Re: Windermere Final Plat (SF-21-026)

Please accept this response letter to comments received August 10, 2021

RD03

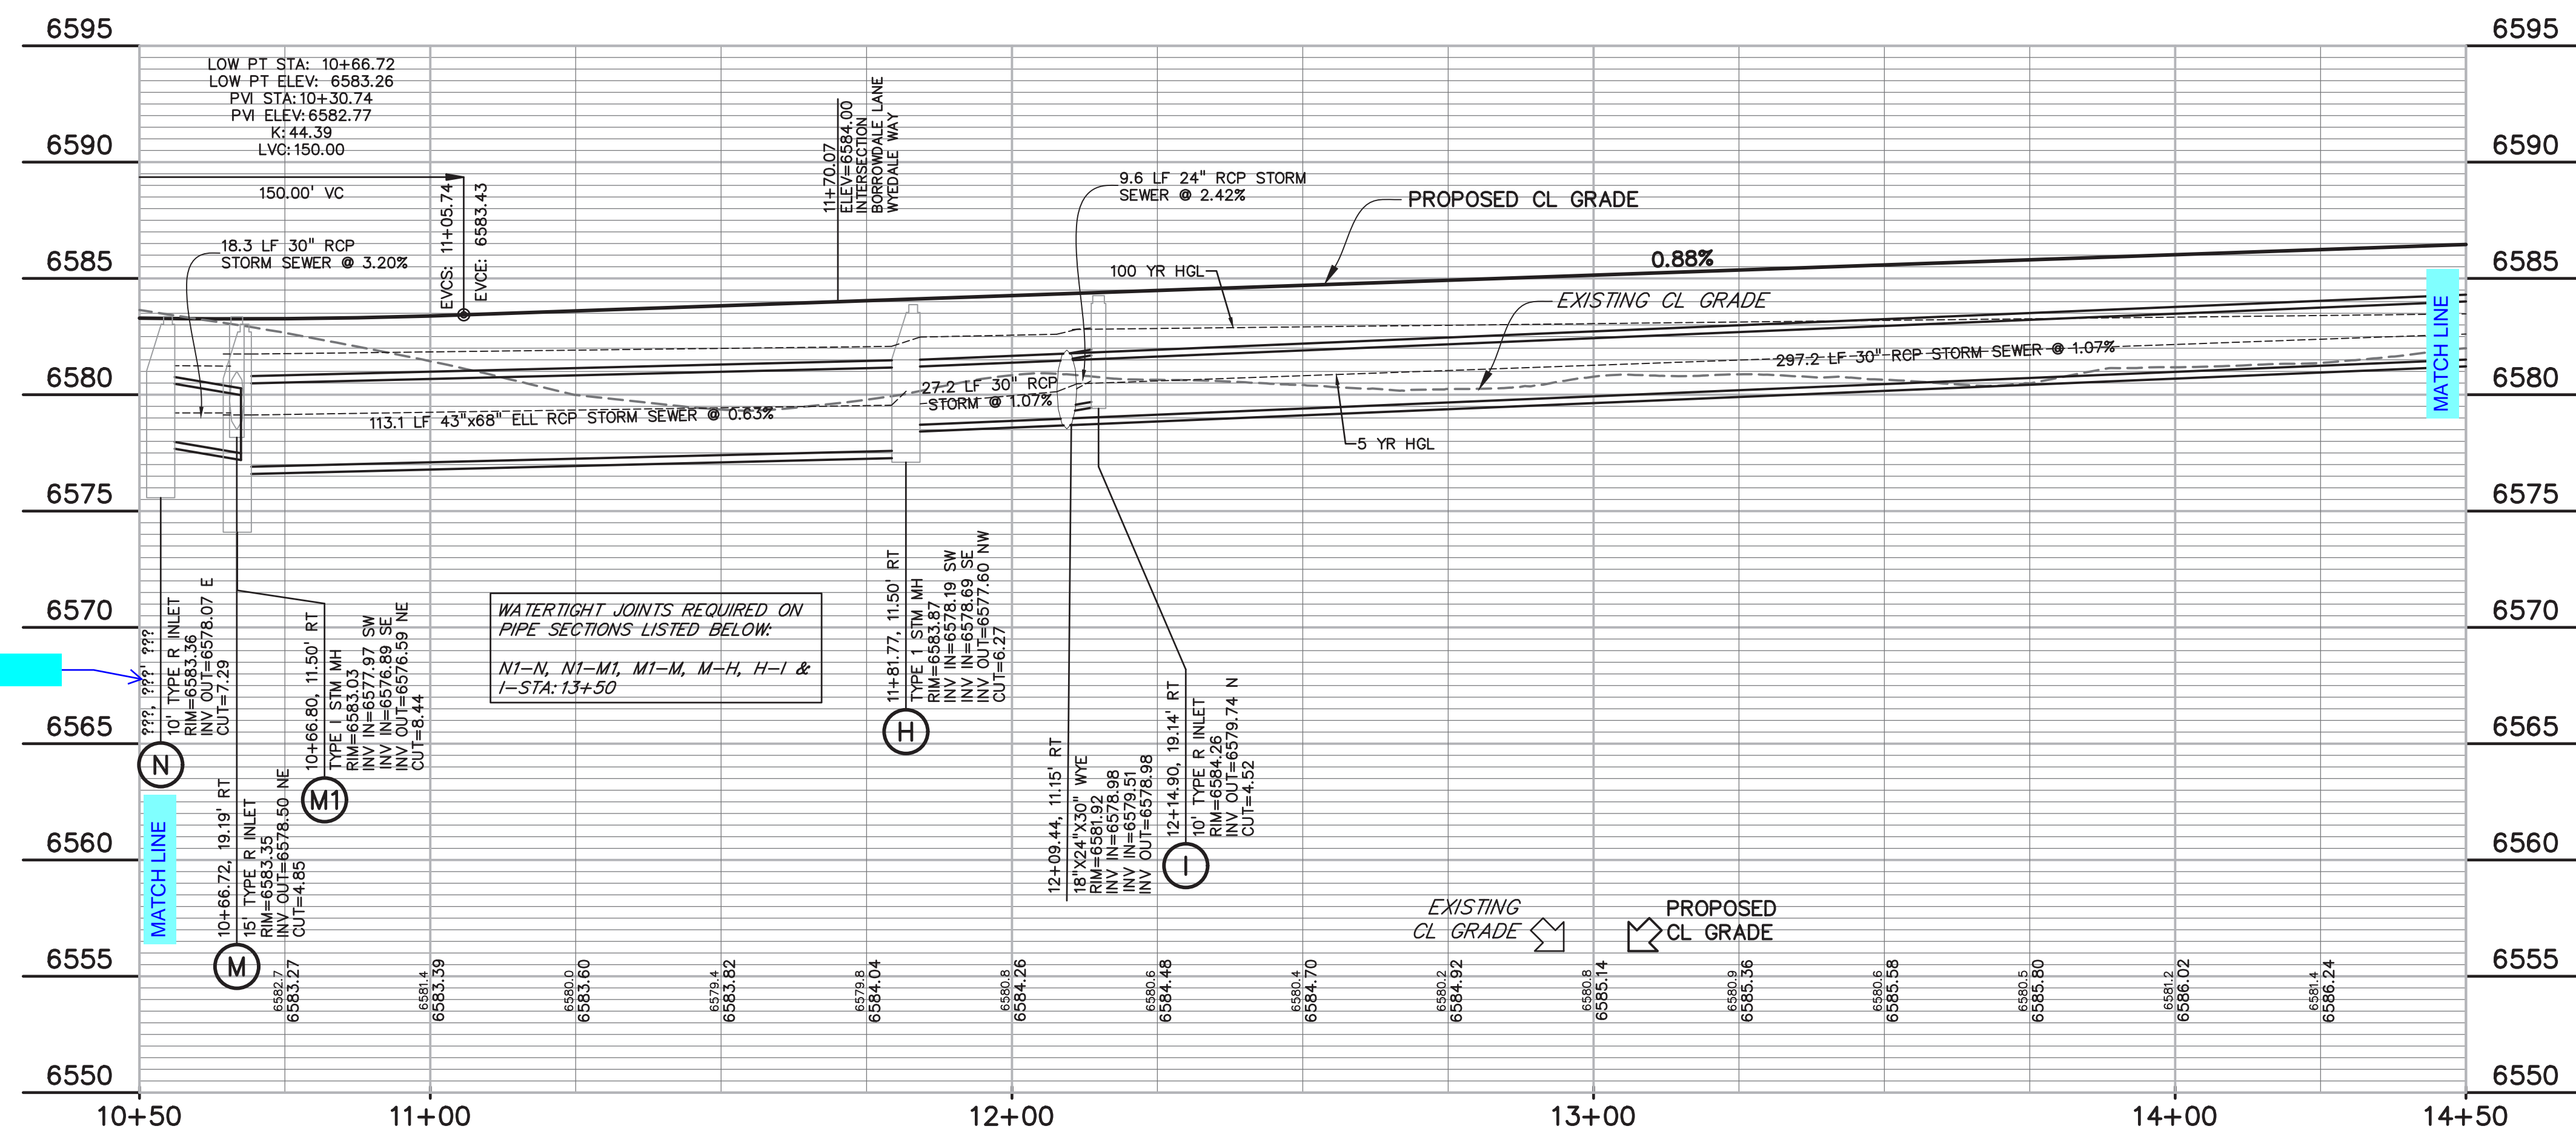
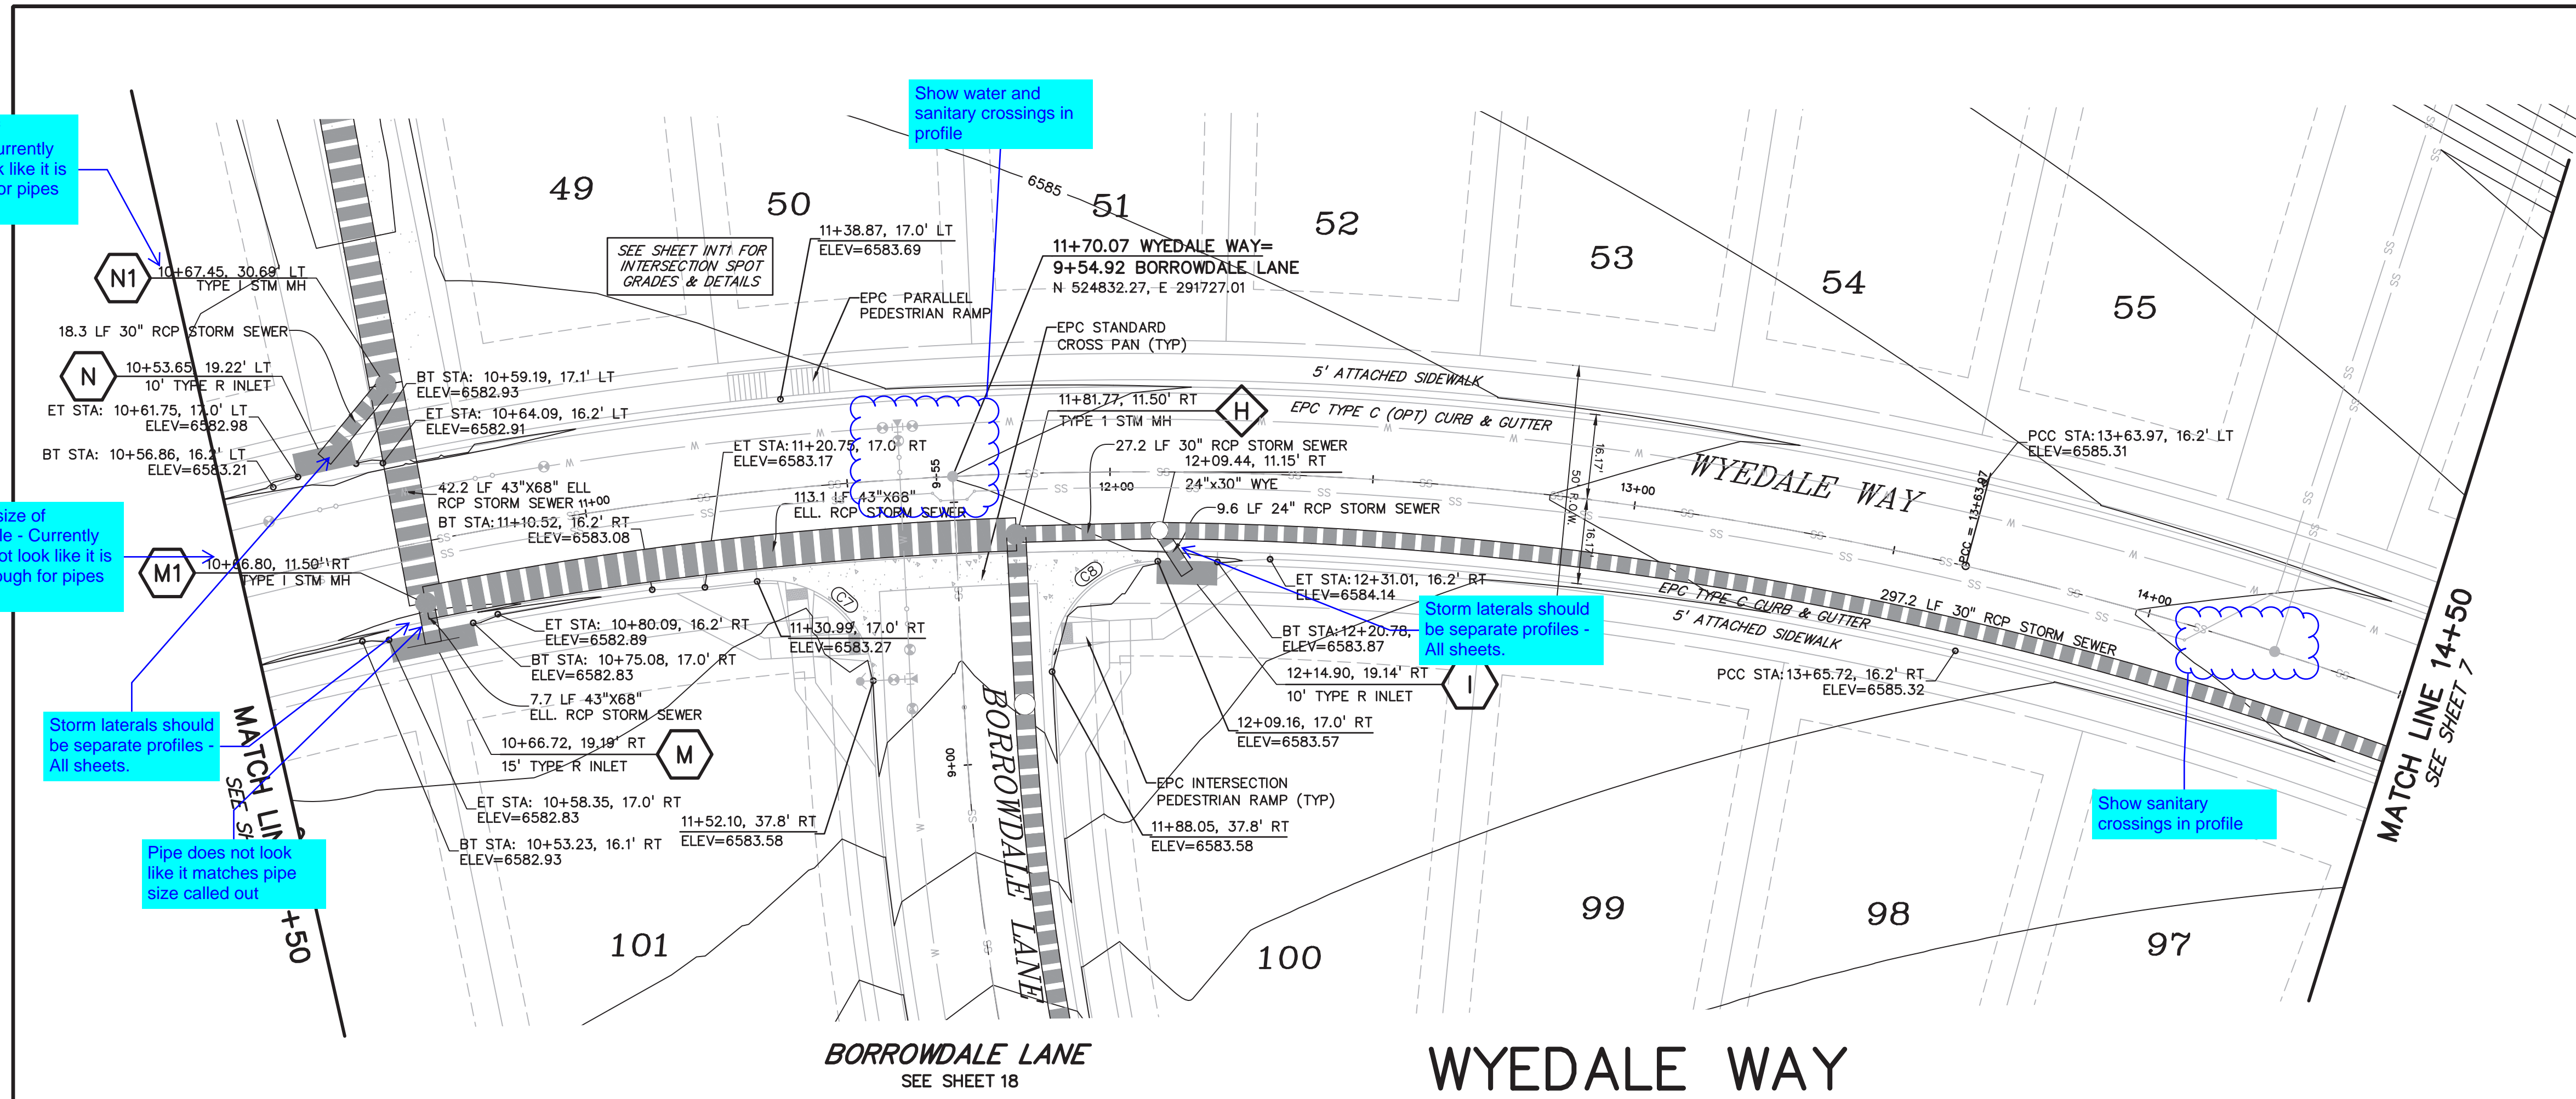
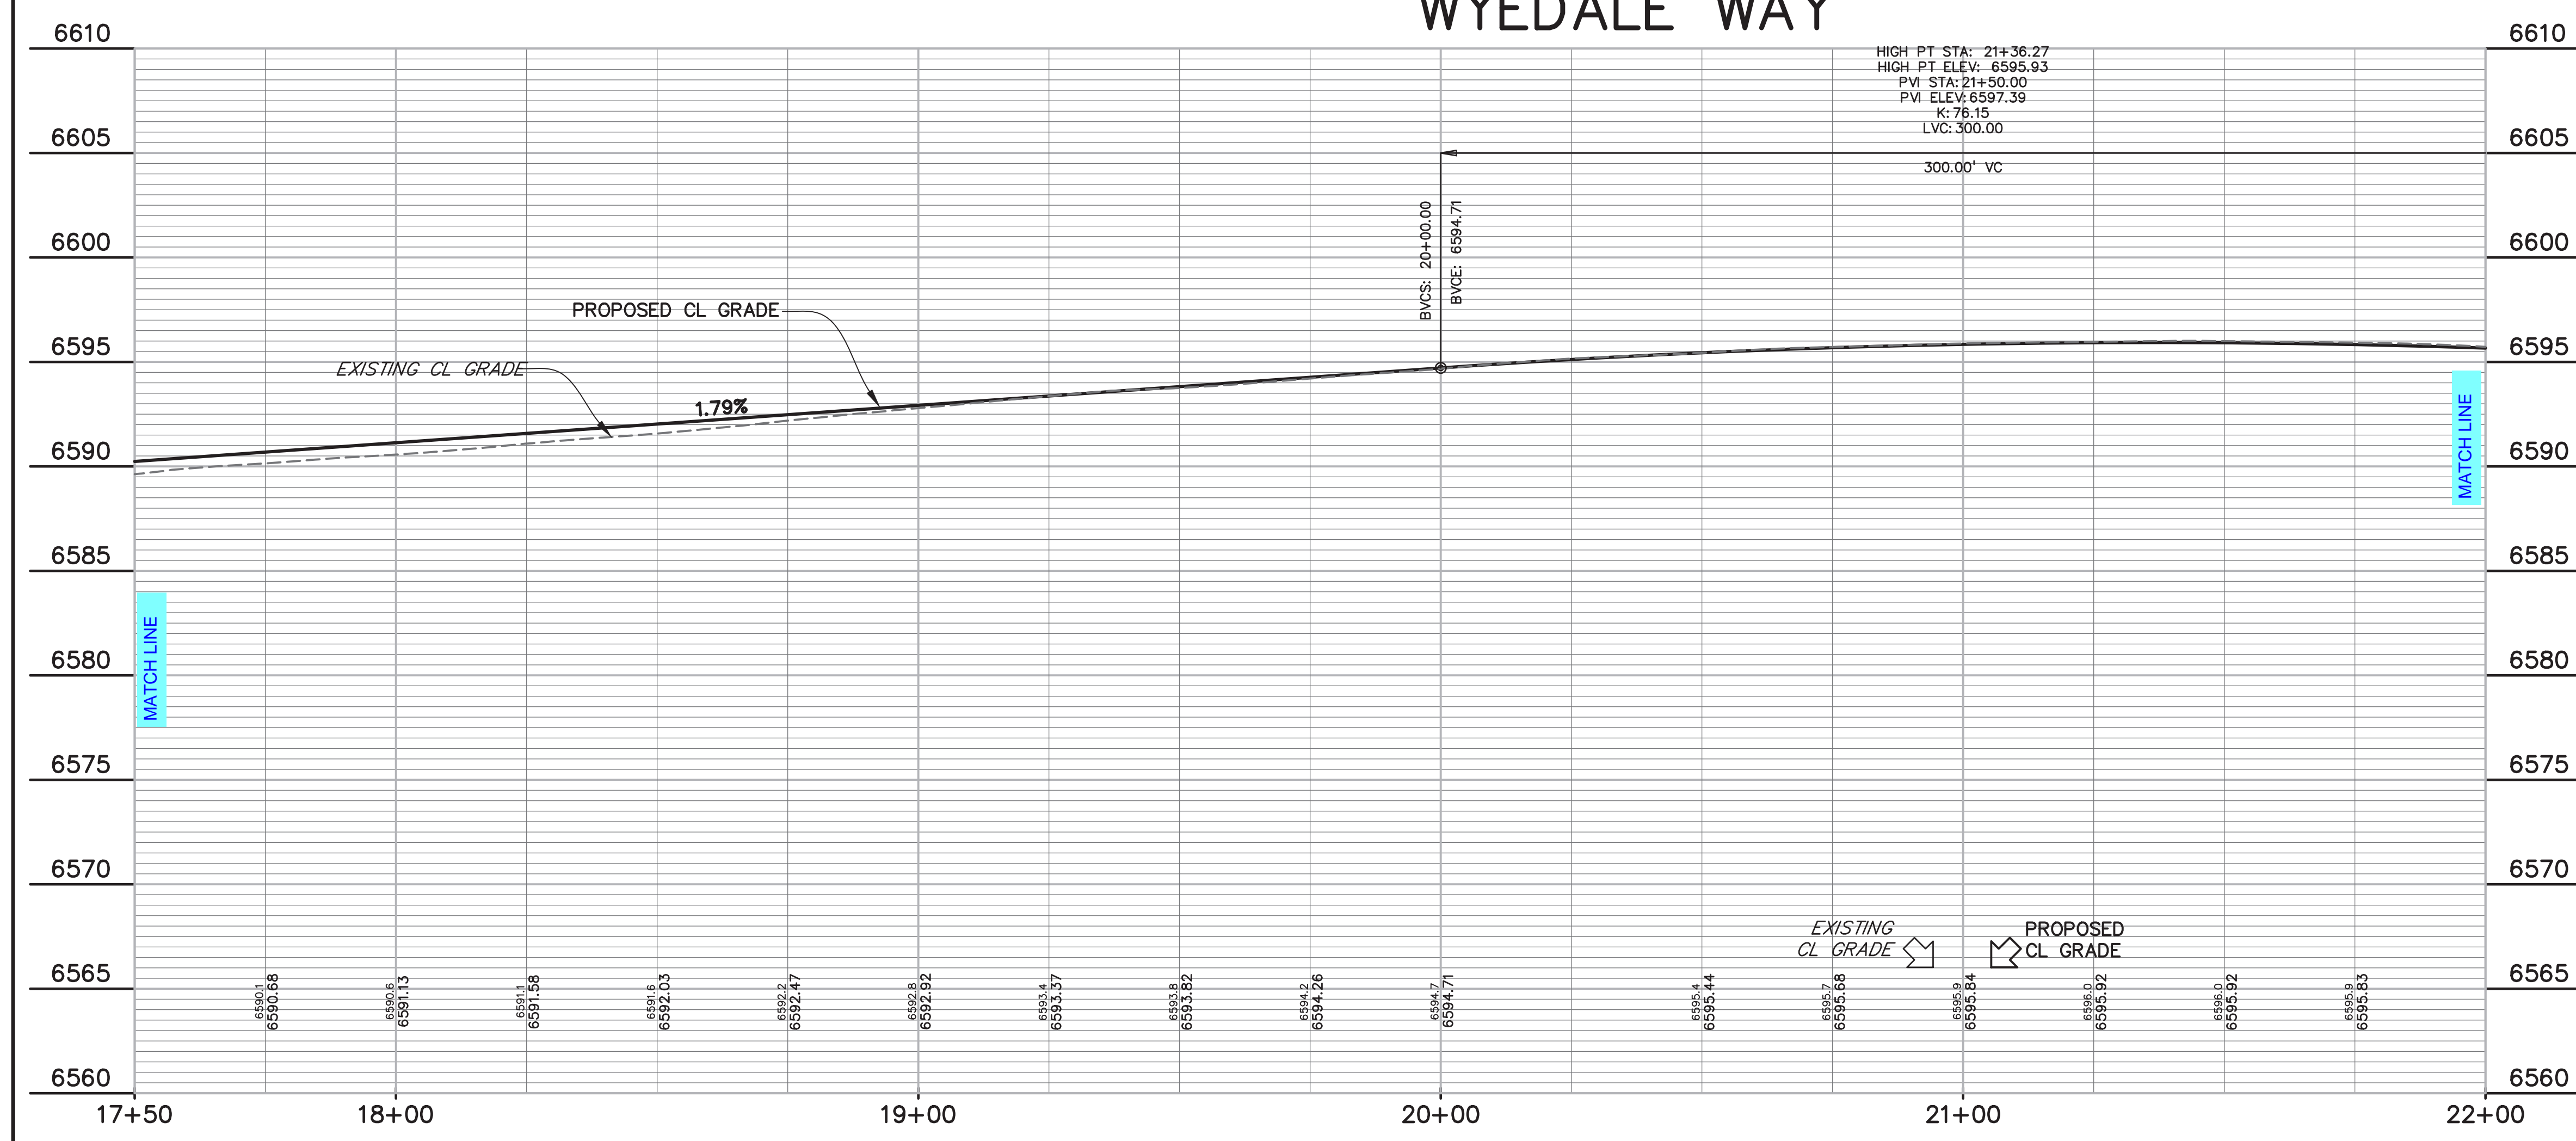
2. See Final Plat comment #2. **Intersection has been revised.**
3. Provide notes specifying watertight pressure pipe (ECM 3.3.1.D - exceeding short runs with a pressure head) where applicable. **Notes added to plans.**
